MECKLENBURG COUNTY
Park and Recreation Department

MEMORANDUM

DATE: September 19, 2022

RE: Rezoning Petition #2022-070
PID# 02505102, 03

# Liberty Crossing Mixed-Use Rezoning Site Plan

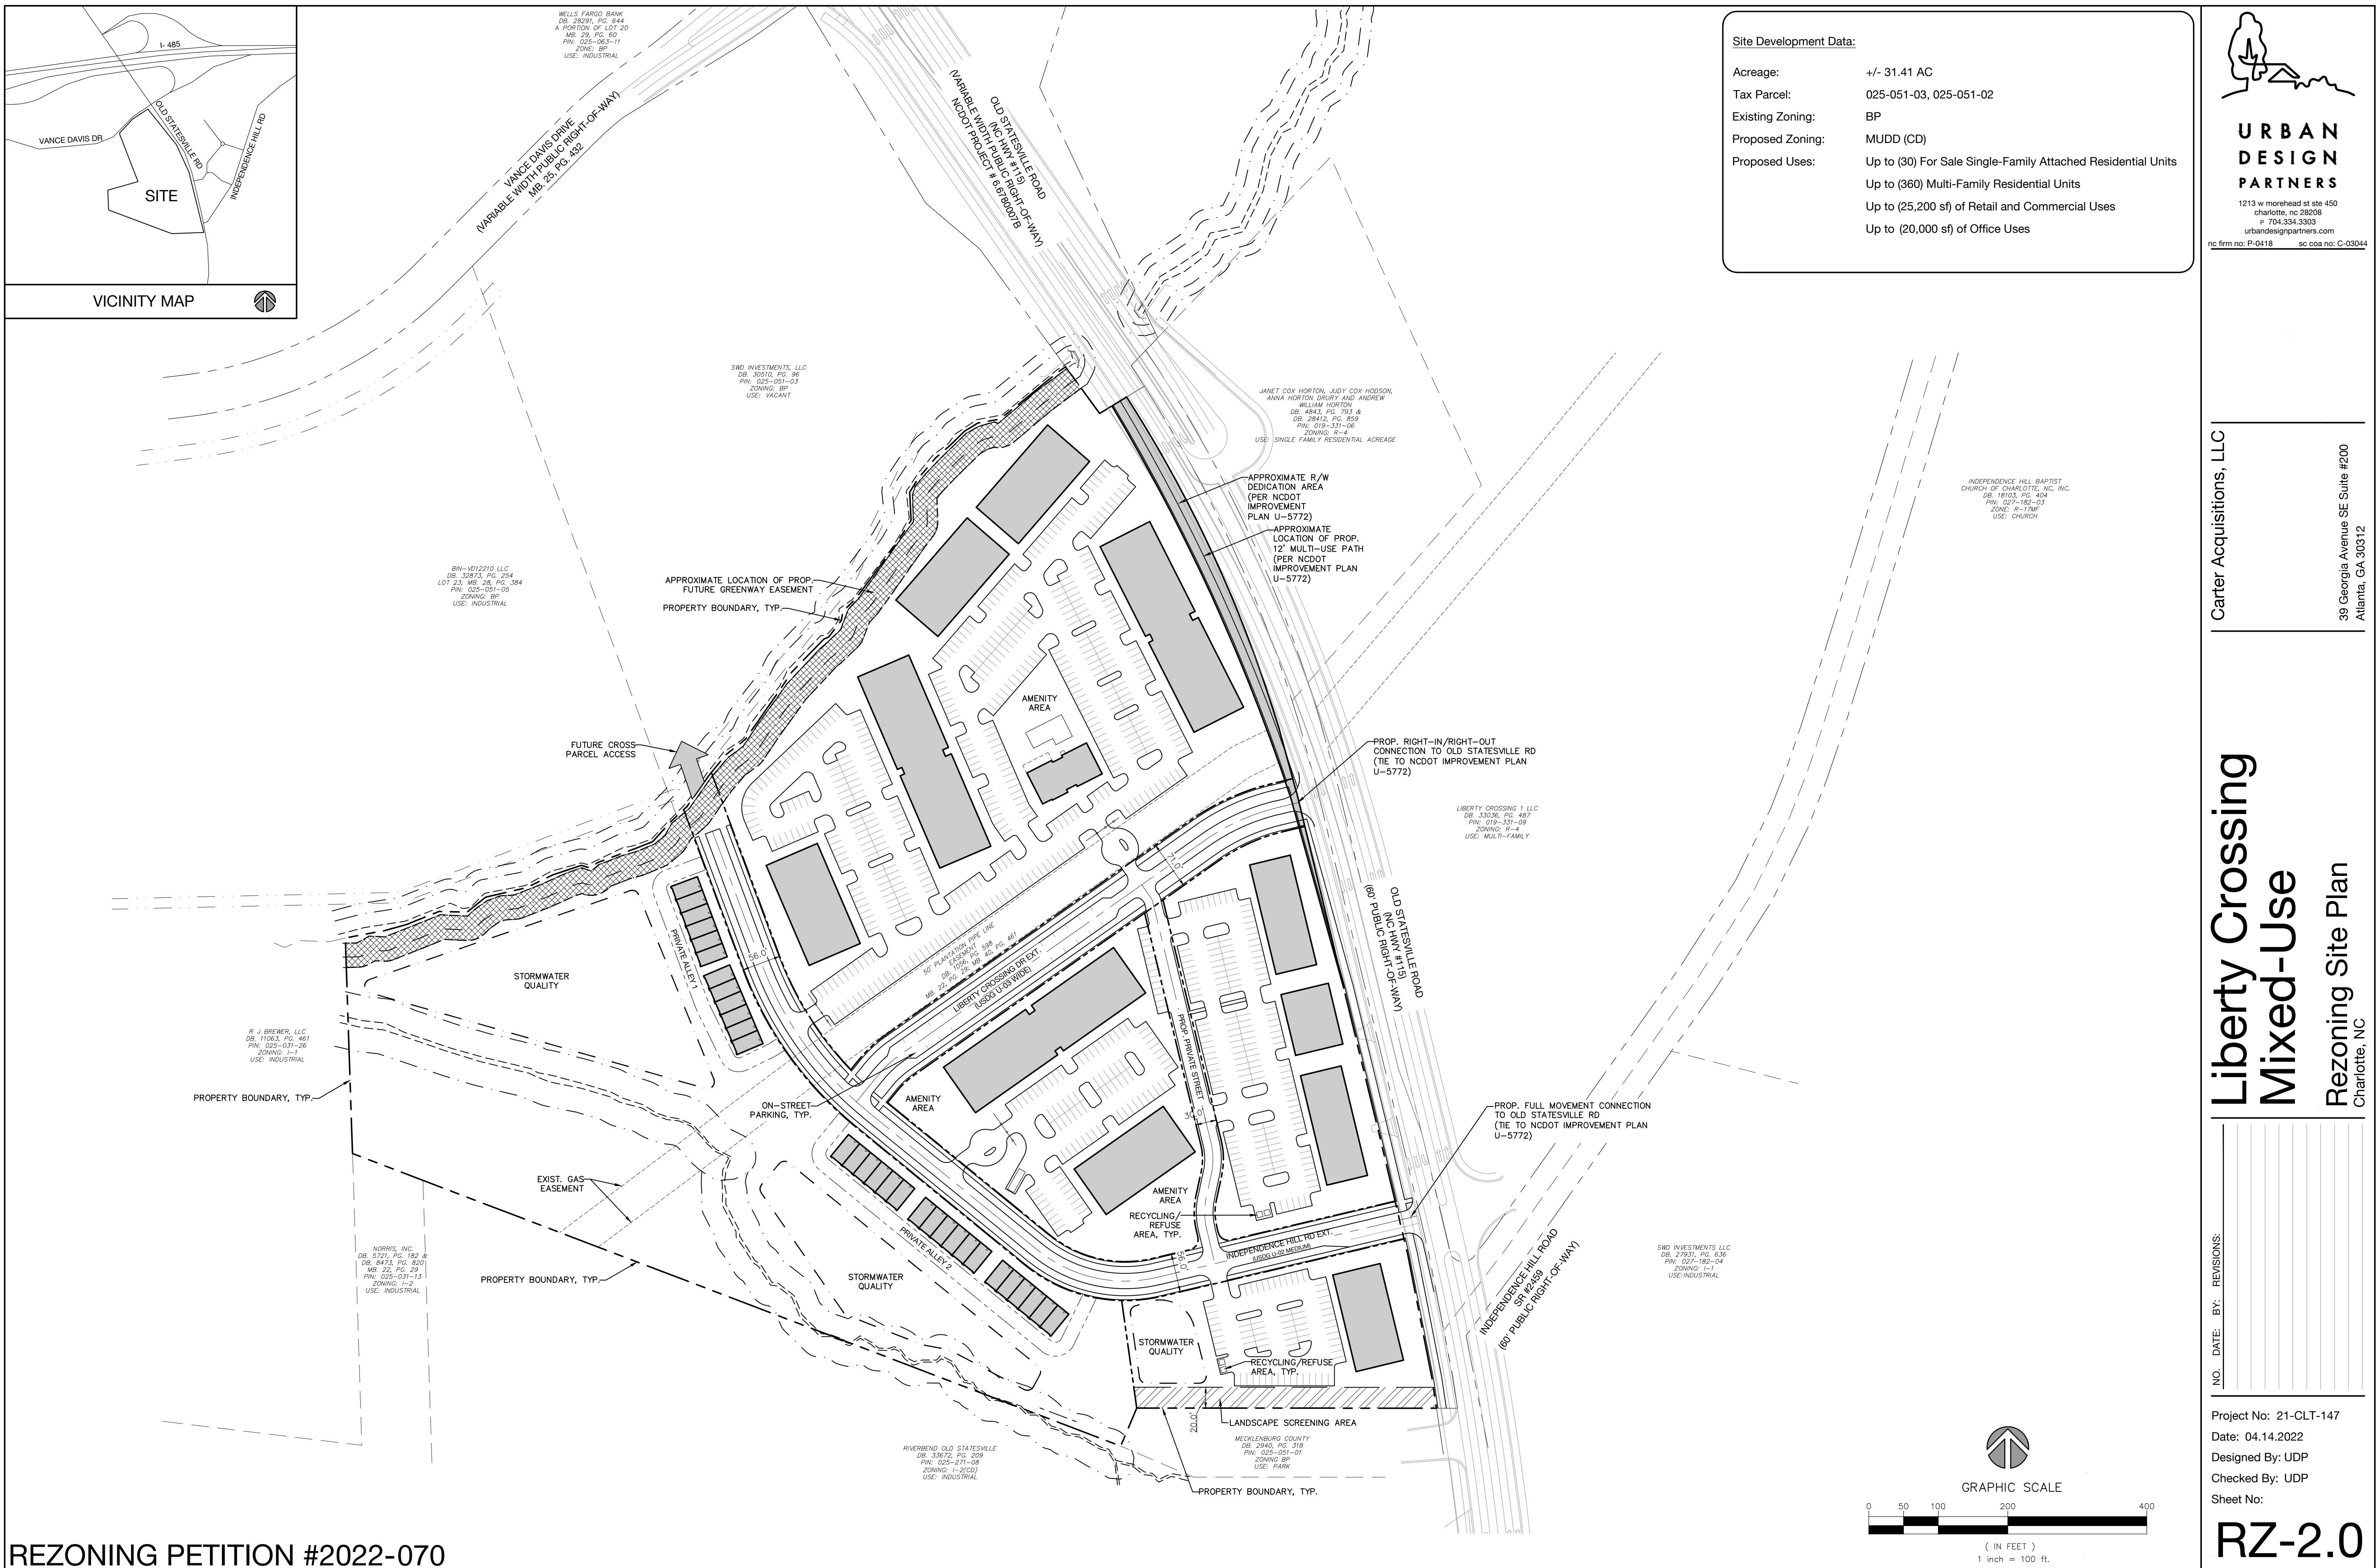
MCPR requests a minimum of **1.5** acres to be dedicated and conveyed to Mecklenburg County for a future neighborhood park. This requested park land shall be adjacent to a public right-of-way for access and is conducive for the development of the typical amenities found in a neighborhood park and cannot include tree save parcels or stormwater BMP's. We request bike/pedestrian connectivity to the site from our property. Lastly, The Alexandria Historic Site is undergoing an interpretive master planning process in 2023 and Park and Rec would like to work with the developer to ensure congruence.
